Kurri Kurri Battery Recycling Facility

Response to Submissions

Battery Recycling Facility | 129 Mitchell Avenue, Kurri Kurri | SSD 7520

Report J15156RP1 | Prepared for Pymore Recyclers International Pty Ltd | 24 February 2017

Figure 2 – Project layout

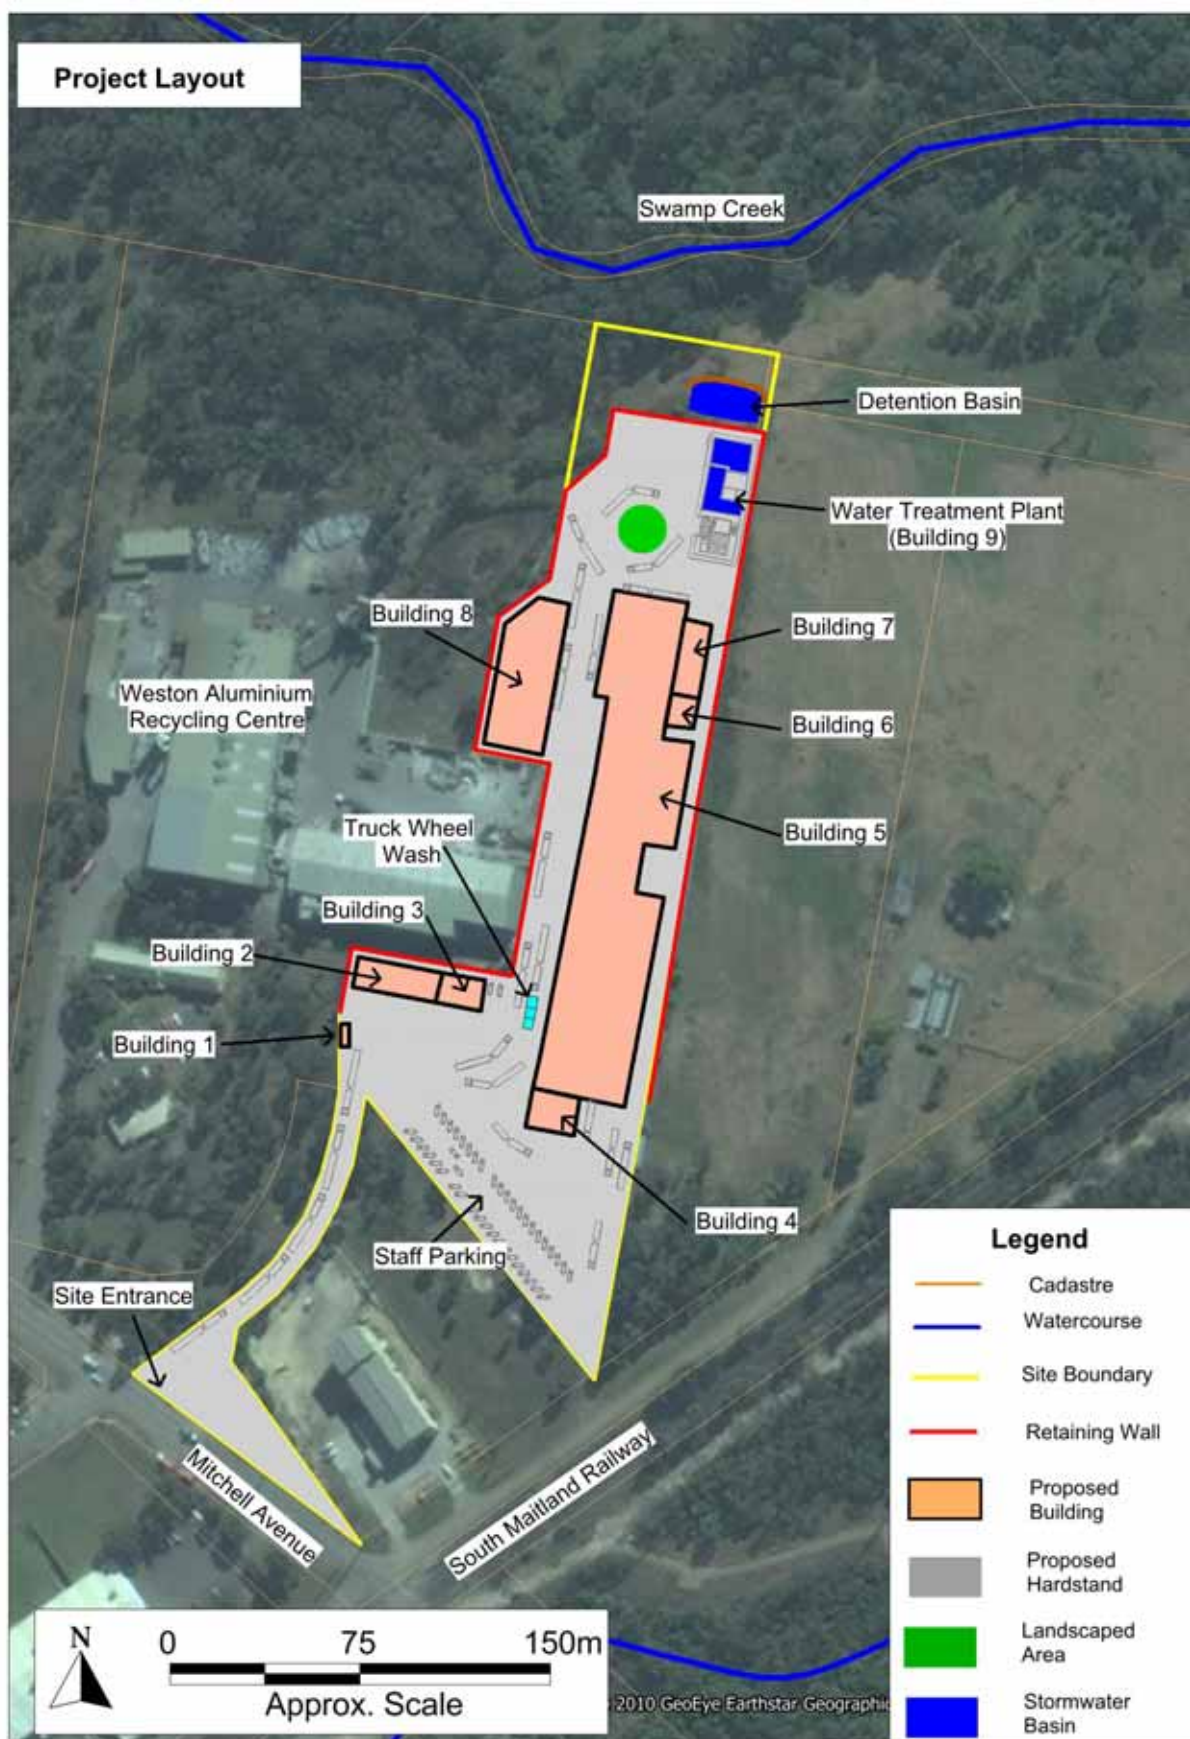
Matters to be addressed	Response
<p><i>Detention basin</i></p> <p>An on-site flood water detention basin is proposed to be located on the floodplain. This will be ineffective in mitigating the full range of events required by Cessnock City Council because the basin is proposed to be located with a crest below the 1 % AEP flood level. OEH recommends that the need for this flood water detention basin is discussed with council officers. If it is required to be installed then the detention basin will need to be relocated above the 1 % AEP level. Such a move may change the extent of fill and site disturbance currently proposed for this project.</p> <p>Significant stormwater storage, treatment and reuse is proposed on site however this system has long draw down times if filled by a large or extended rainfall event. The effectiveness of stormwater storage does not form part of this assessment but should form part of the Environment Protection Authority's licensing requirements.</p> <p>Based on the review of the flood risk assessment for this project OEH is unable to complete its assessment until the difference in probably maximum flood height levels is resolved. Once this is completed OEH will be in a position to provide recommended conditions of consent.</p>	<p>Refer to the above response regarding the proposed detention basin location. This justification was accepted by OEH's Senior Natural Resource Officer (Floodplain) Angela Halcrow in correspondence to Chris Kuczera from Royal HaskoningDHV on 14 February 2017.</p> <p>The stormwater capture and untreated water storage basins will have a collective storage capacity of 1,412 m³. This is equivalent to 41.5 millimetres (mm) of runoff from the 3.4 hectare (ha) site. The ULAB recycling process will use an average of 46 m³ of water a day. This water will be sourced from the untreated water storage basin, which will enable the stormwater capture basin to be progressively dewatered at a similar rate. Water balance modelling that is documented in the Surface Water Assessment estimates that, on average, 60% of runoff will be captured and used in the ULAB recycling process and 40% of runoff will discharge from site, following treatment in the detention basin.</p>
